Mayfield West Waste Facility-Mod-1 (SSD-7698-Mod-1)
Request for additional information

I refer to the assessment for the Mayfield West Waste Facility Modification 1 (SSD-7698-Mod-1). After careful consideration, the Department is requesting the following additional information:

Figure 1

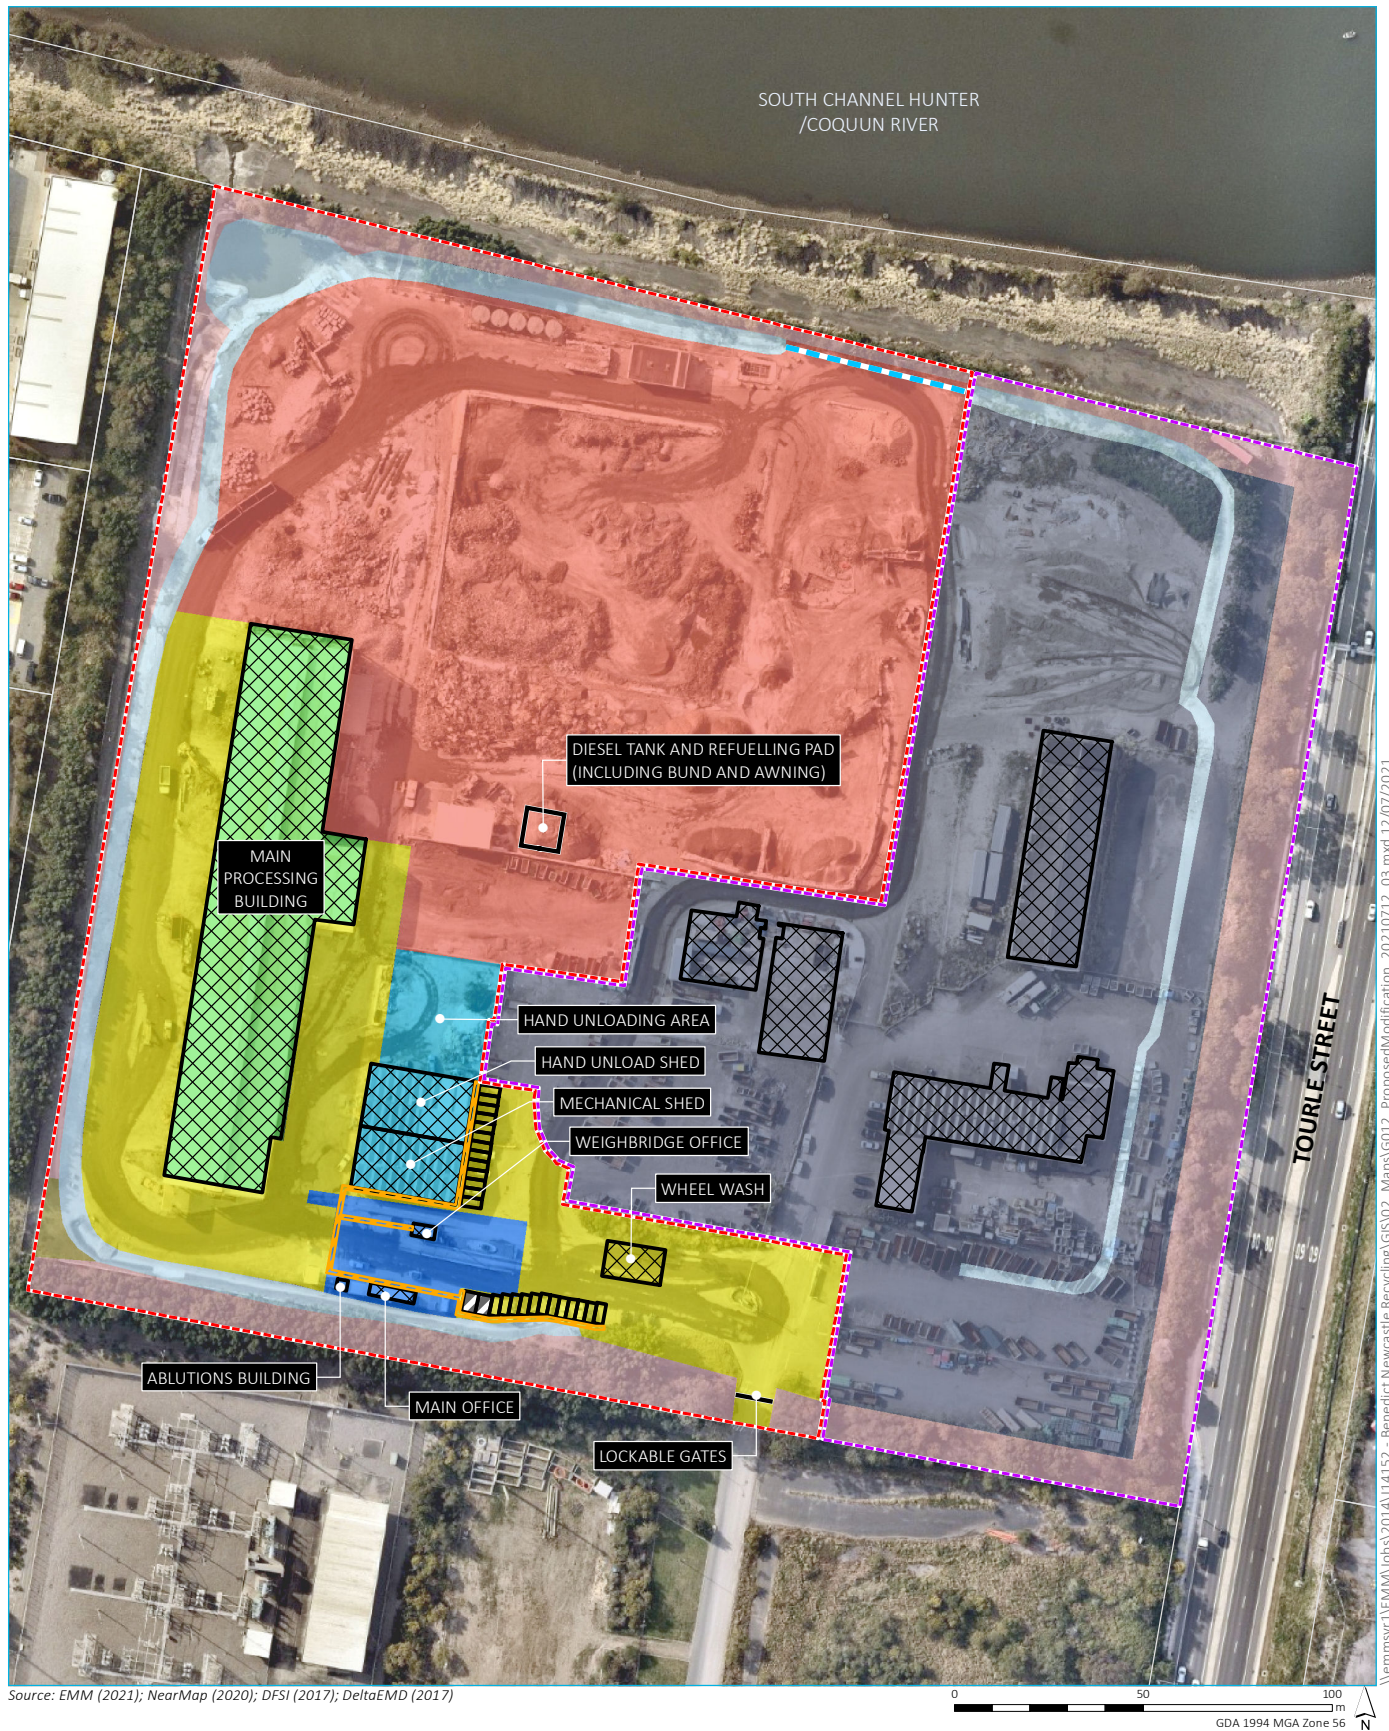
- Provide a copy of the EMM advice to support section 5.2.2 of the Modification Report.
- Provide an updated Development Layout Plan (Appendix A of SSD 7698)
